Charlotte Department of Transportation

Memorandum

Subject: Rezoning Petition 08-155: Located on the east side of South Tryon Street
between Yorkdale Drive and Thornfield Road
(revised 11/14/08)

**S. TRYON STREET**  
**REZONING PETITION NUMBER: 2008-155**  
JDR COMMUNITIES  
CONCEPTUAL SITE PLAN

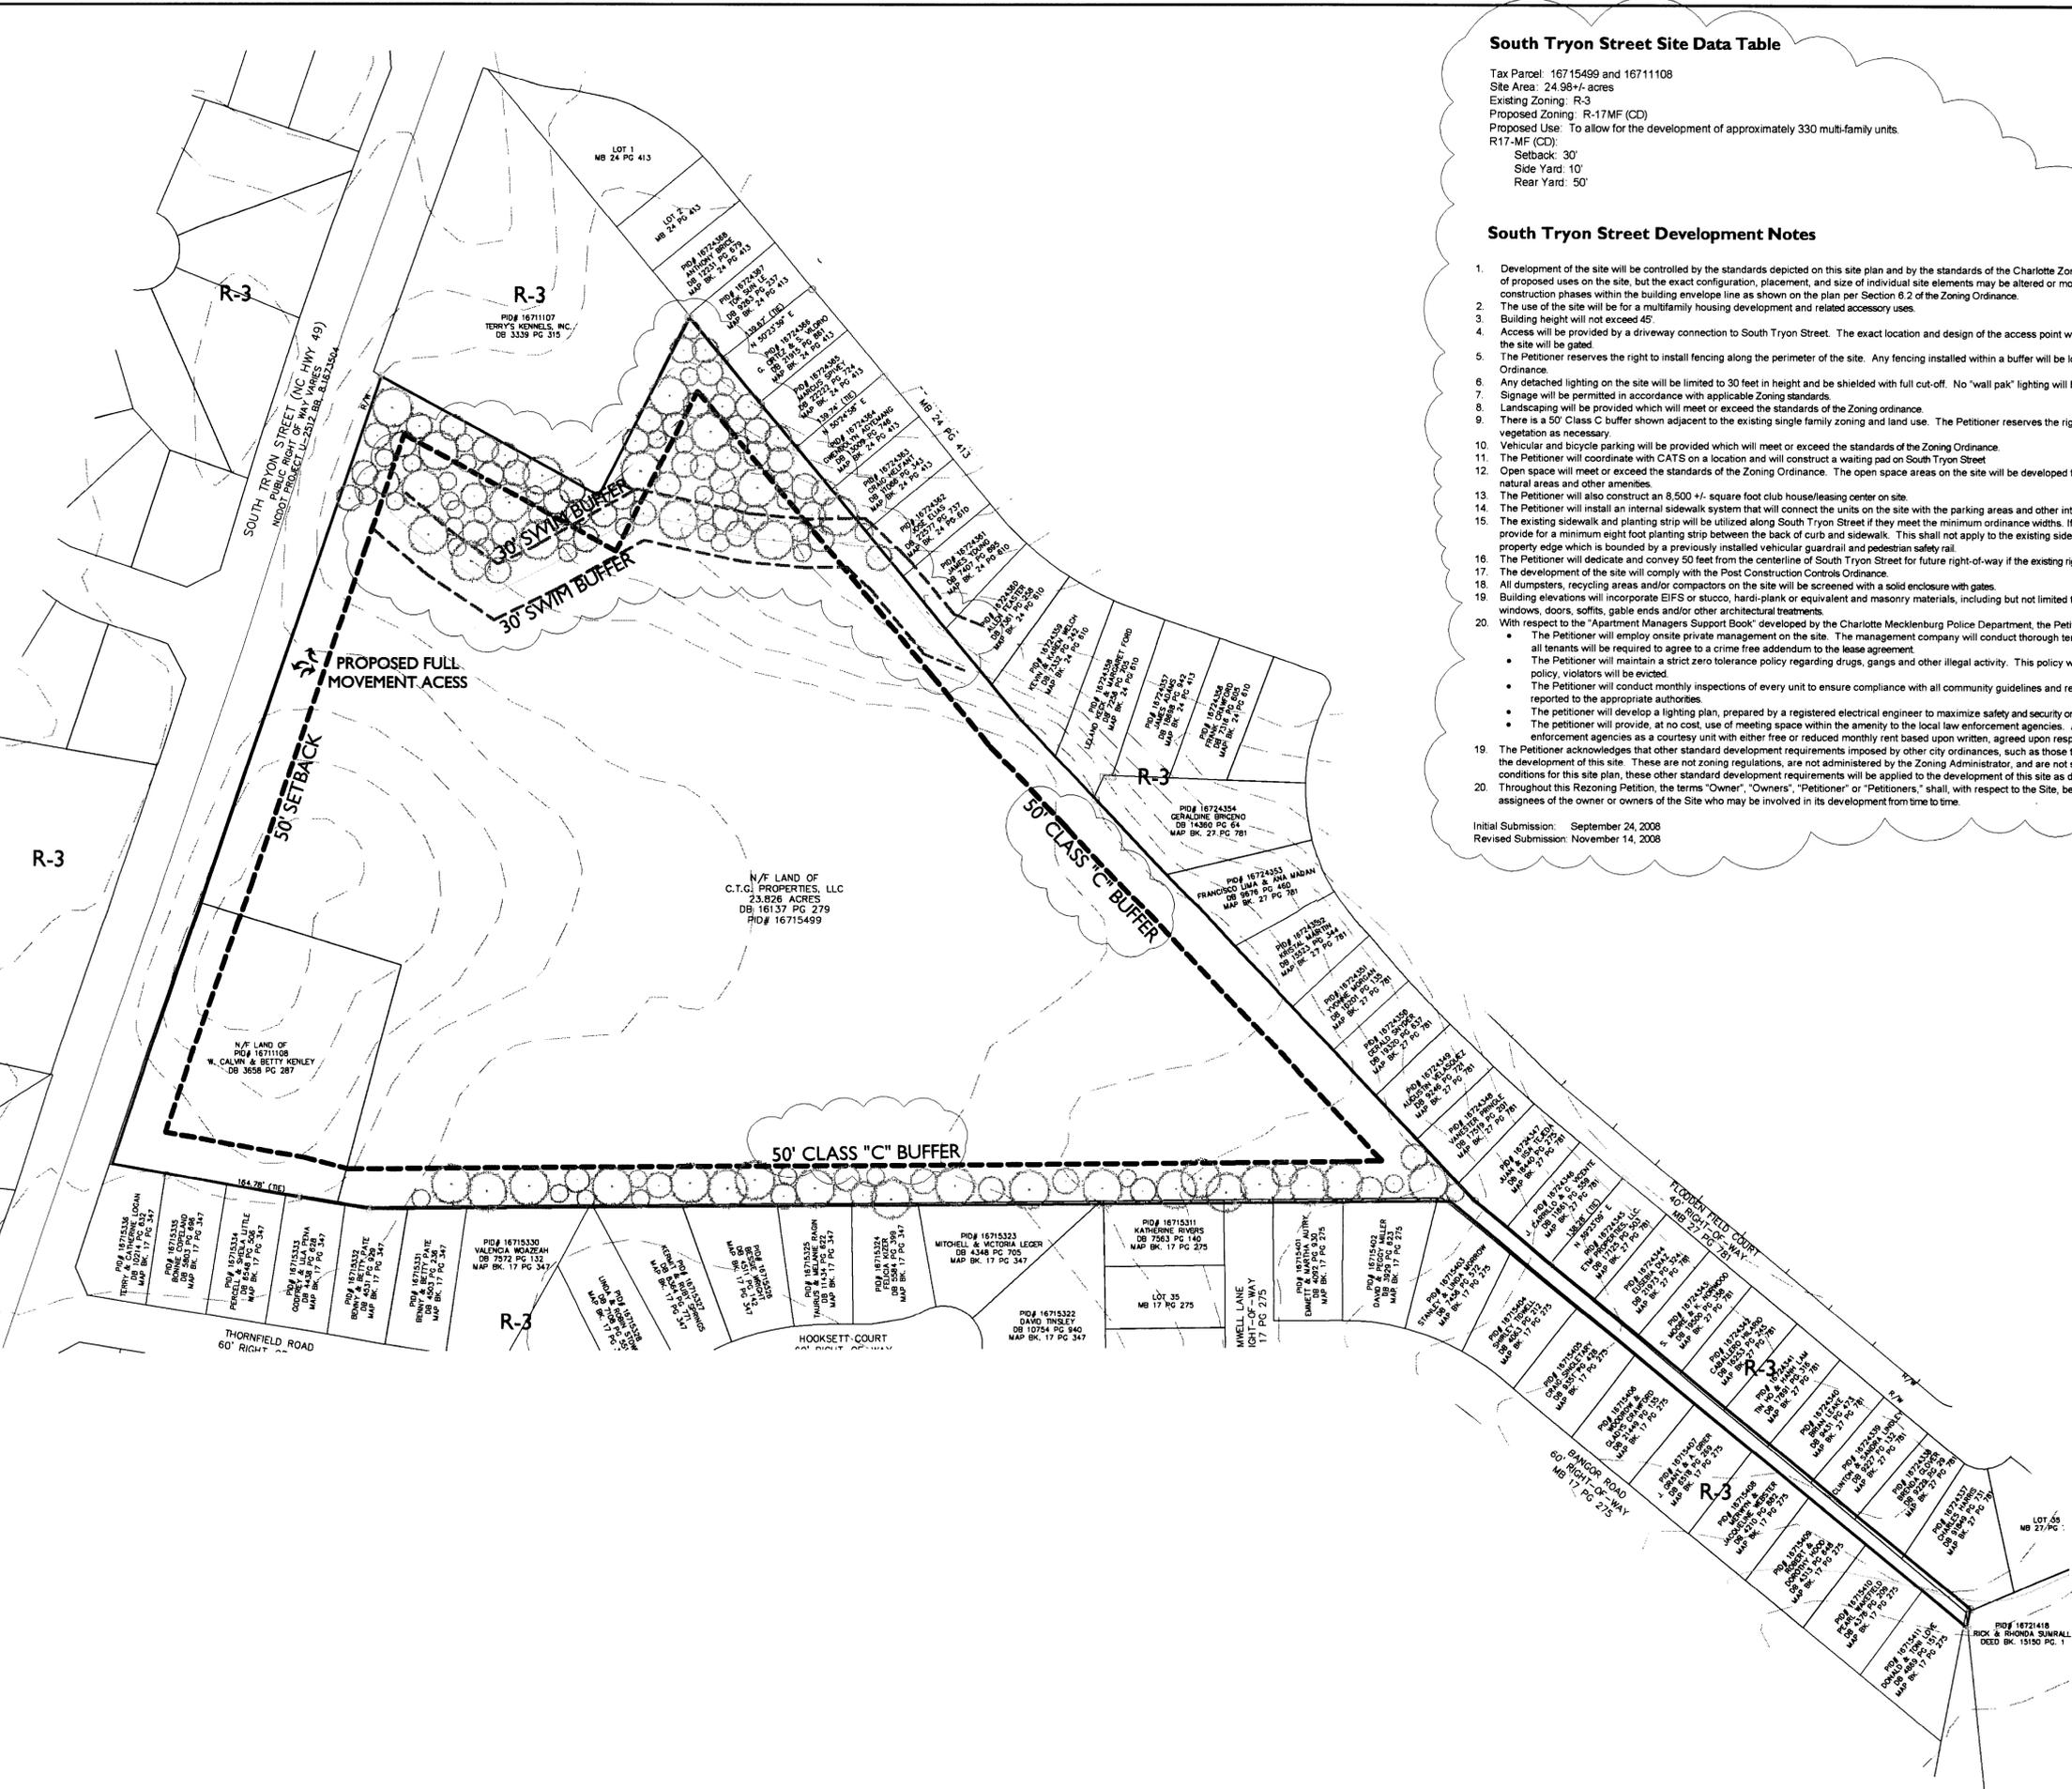
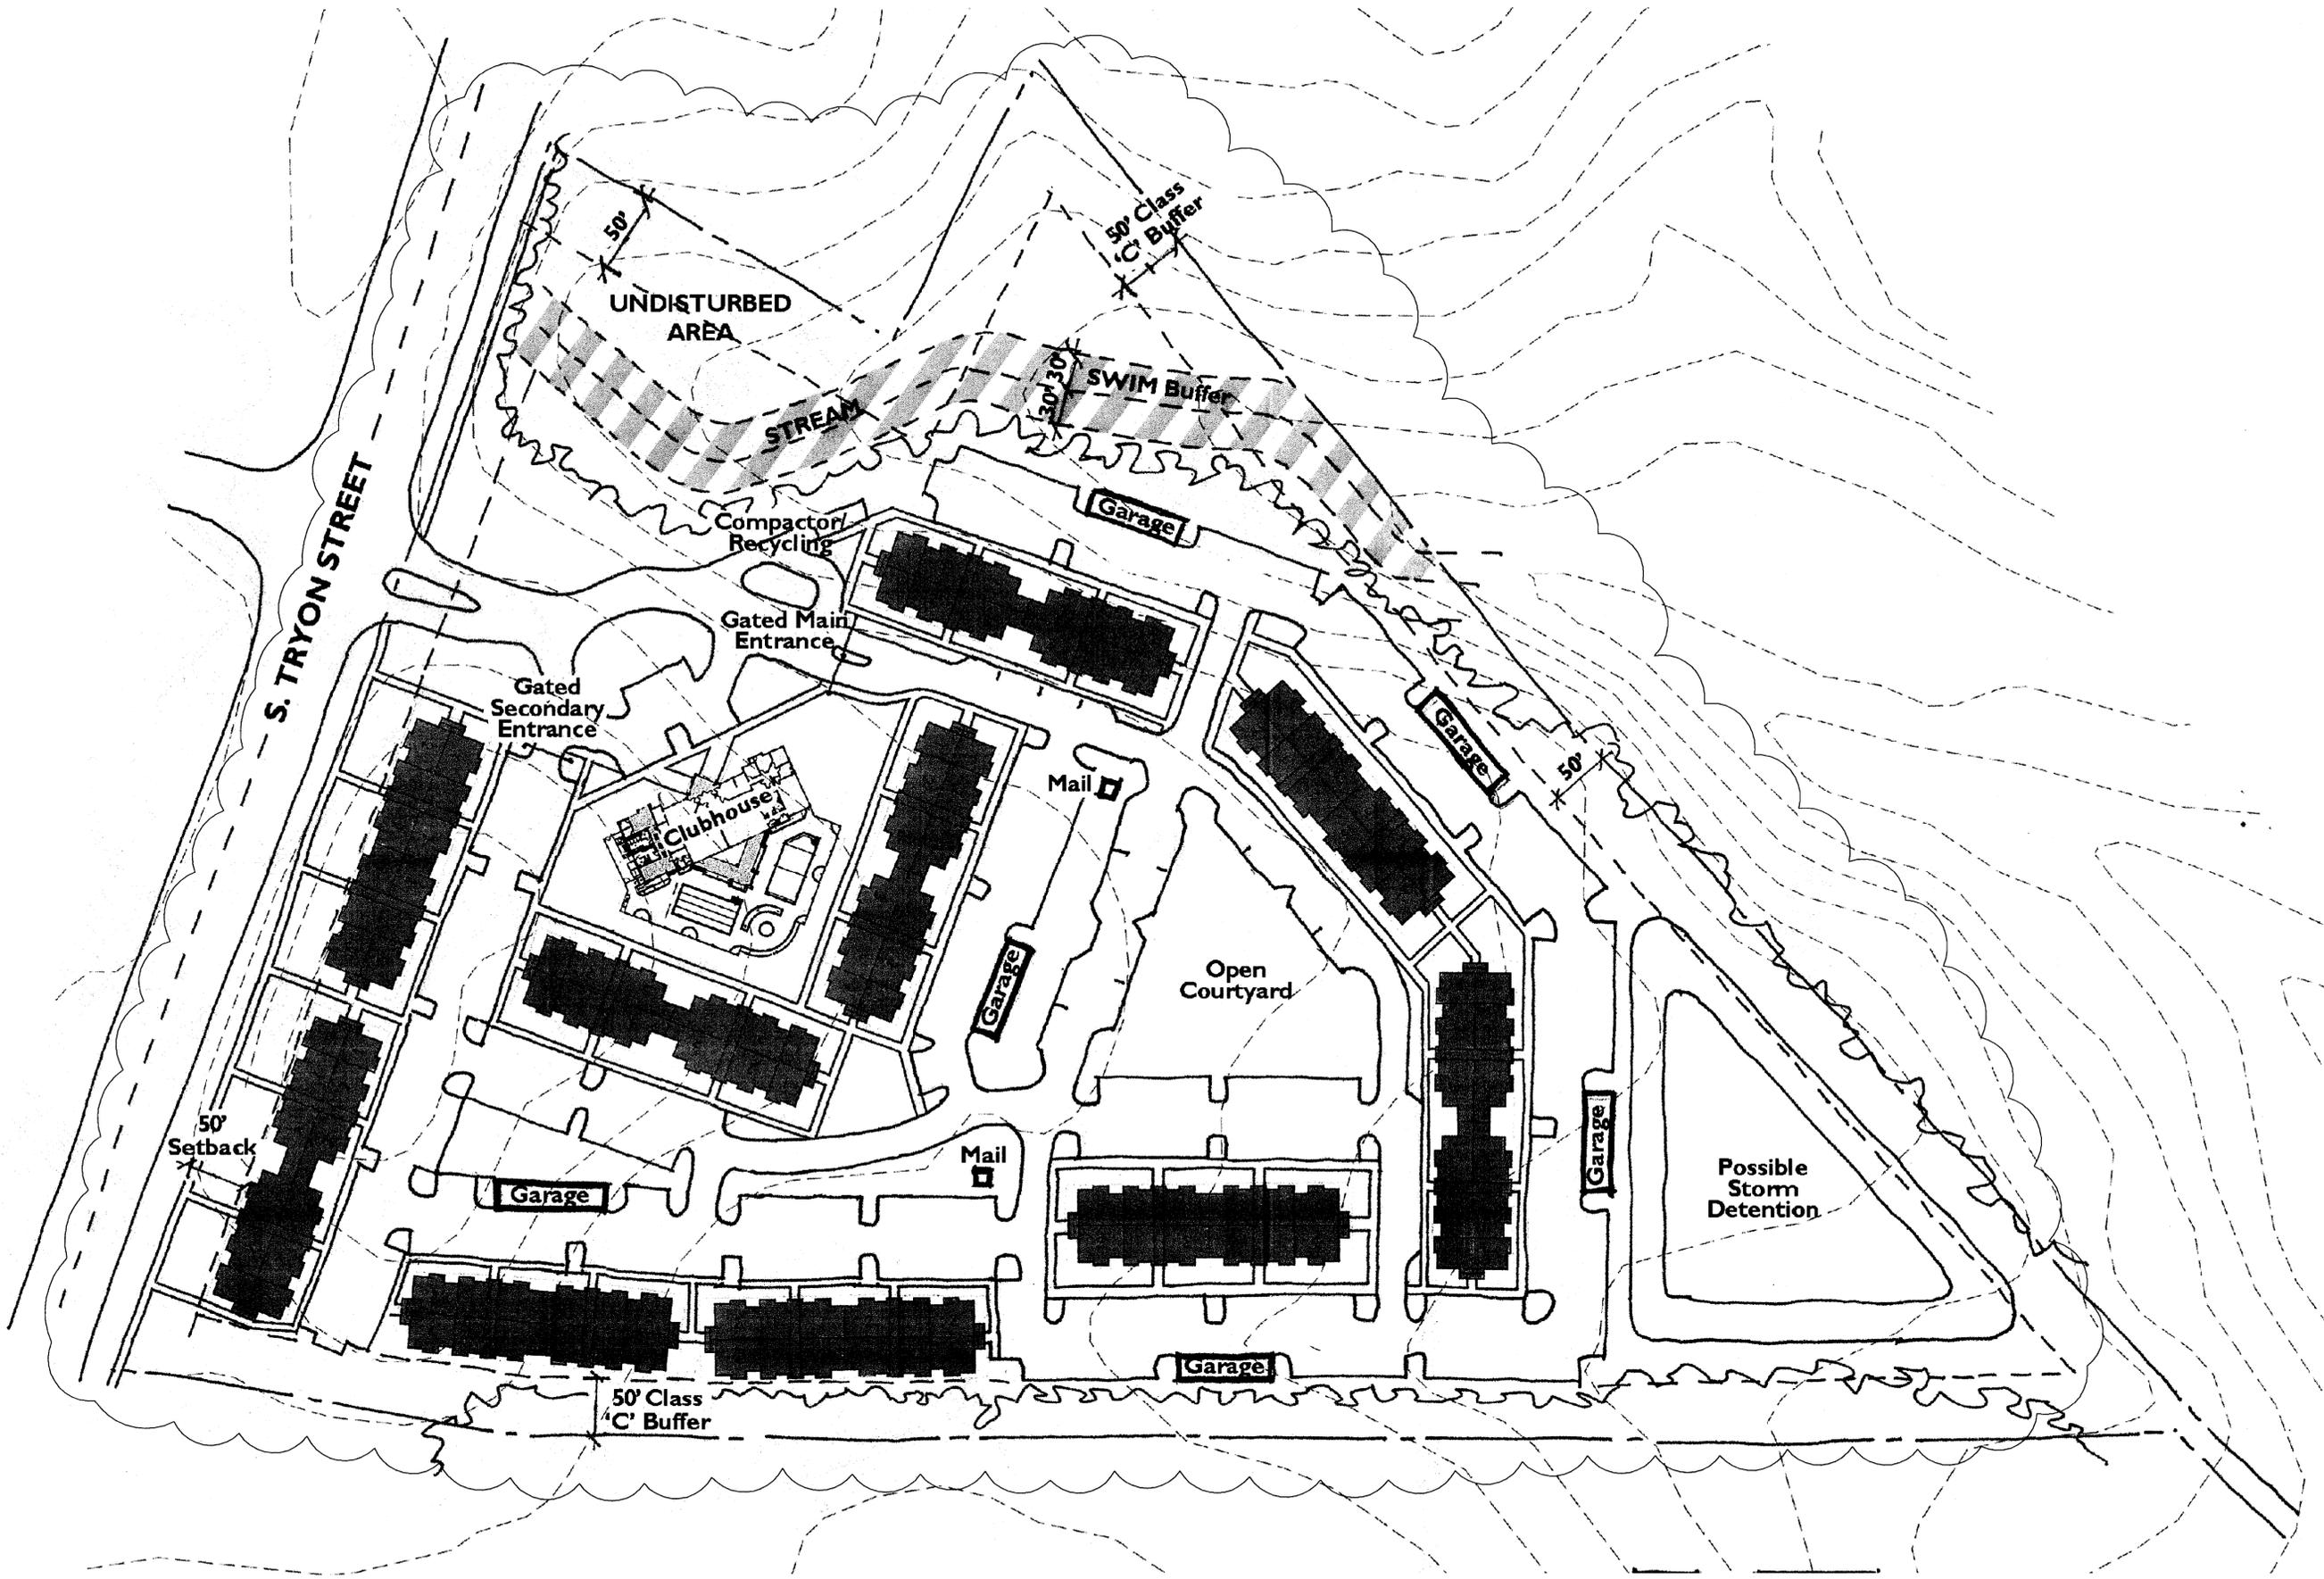
1. The developer needs to dedicate a 60-foot wide public right-of-way, which could be a network of public streets, between the full-movement access point on South Tryon Street located opposite Olde Whitehall Road and Cormwell Lane. Within such right-of-way, the developer needs to construct a new street following the Urban Street Design Guidelines

(USDG) for a Local Residential Street – Wide. Such street has a 35-foot back-of-curb width with 7-foot parking lanes, 8-foot planting strips and 8-foot sidewalks (for densities over 12 units per acre). *(Previous review comment)*

2. CDOT has determined that a left-turn lane on South Tryon Street is necessary to serve the traffic using the proposed private driveway connection for this site. The engineering design and construction of the left-turn lane is the responsibility of the owner and shall be performed by a professional engineer registered in the State of North Carolina who has roadway design experience. The left-turn lane needs to follow the NCDOT design guidelines with a minimum of 150 feet of storage and will be reviewed during subsequent permitting processes. *(Previous review comment)*

3. In the Development Notes, note 15 needs to be modified to indicate a 6 foot sidewalk and 8 foot planting strip will be provided.
4. In the Development Notes, the portion “All access points will be gated” needs to be removed from note 4. *(Previous review comment)*

5. The existing geometric features, (curb & gutter, sidewalk, accessible ramps, etc.) need to be shown on the site plan in order to further evaluate this petition. *(Previous review comment)*

1. The extension of Cormwell Lane through the proposed development should T into the public street connecting to South Tryon Street described above, so as to provide built-in traffic calming. CDOT encourages the developer to consider a roundabout at this intersection.
